Our Case Number: ABP-318573-23

An
Bord
Pleanála

Date: 08 October 2024

Re: A proposed Road Development comprising of the N2 Slane By-Pass and Public Realm Enhancement Scheme
Within the Townlands of Slane, County Meath

Drawing Number: DR0004	Status: A1	Rev: C01
------------------------	------------	----------

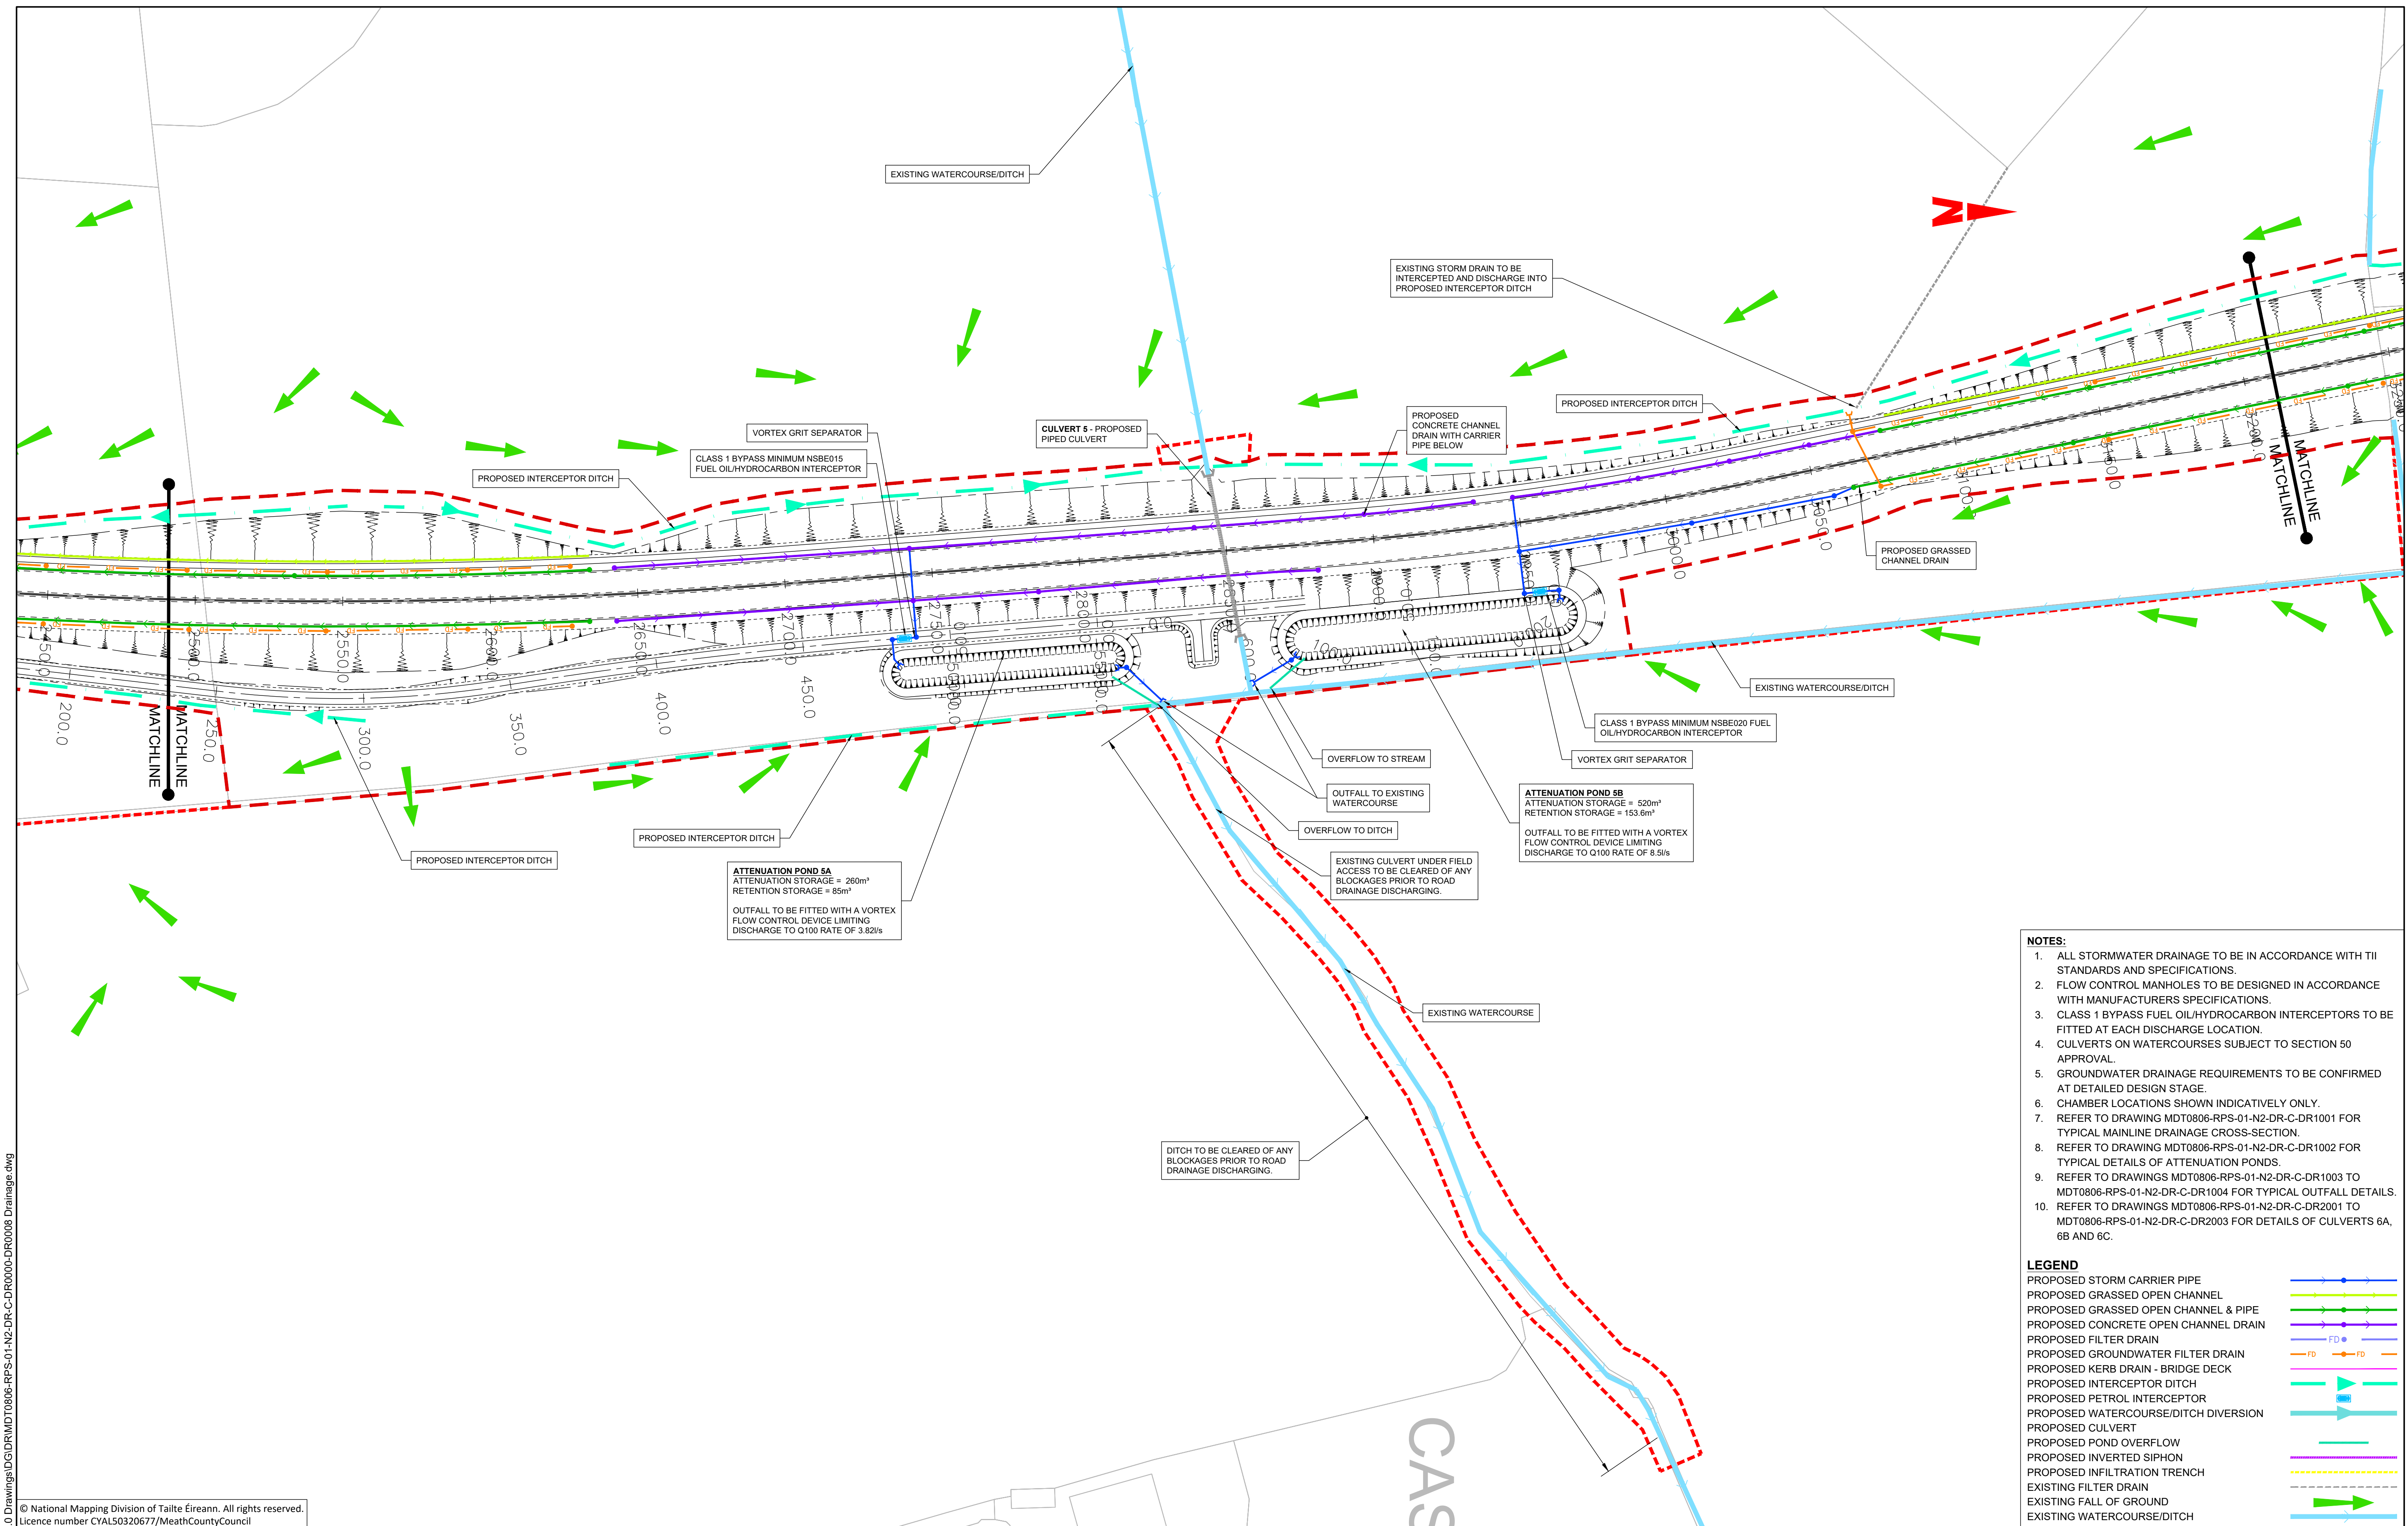
- b) **Riverbank exclusion zone:** An exception is noted to the 10m exclusion zone from the riverbank (e.g. Natura Impact Statement Section 6.2.1.1.1.) for the construction of four outfalls. The applicant shall clarify if this relates to the scour mats shown in drawing DR0004. As there is no further reference to these works in the Natura Impact Statement or Environmental Impact Assessment Report Biodiversity chapters, provide an assessment of same, and describe any mitigation measures (e.g. manual installation, timing of works) required to avoid adverse effects to qualifying interest of the European Sites, or any other habitats, flora or fauna.
